Shenington with Alkerton Parish Council Response – Planning Proposal 22/00489/F

Shenington with Alkerton Parish Council, in light of strong opposition within the parish and in consideration of the significant weaknesses within the planning application itself, recommend that the Planning Committee comprehensively rejects the proposal to build 49 houses on the outskirts of the village.

TITLE:
PLANNING LAYOUT

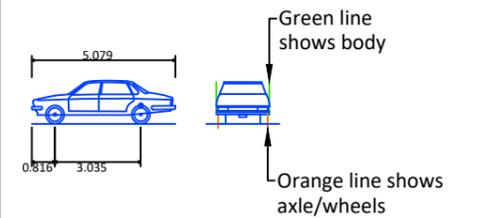
Separately, the proposed egress from the development onto Rattlecombe Road is hazardous, with limited visibility and the lack of pedestrian facilities referred to above. The width of the road does not allow for two vehicles to pass easily and safely past the proposed junction and the ground surrounding it does not seem to allow for good sight lines for traffic exiting it. Furthermore there is no possibility of adding pavements to enhance pedestrian safety. These limitations will be particularly evident during construction. The highways in the village are completely unsuited to a high volume of heavy construction traffic.

- demonstration of suitable visibility in line with the Manual for Streets requirements;
- vehicle turns in and out of the site without overrunning the centre of the road;
- the requirement for visitor parking;
- the "connecting footway [on Stocking Lane] to provide a safe route to the primary school"; and
- consultation with Oxfordshire County Council prior to application.
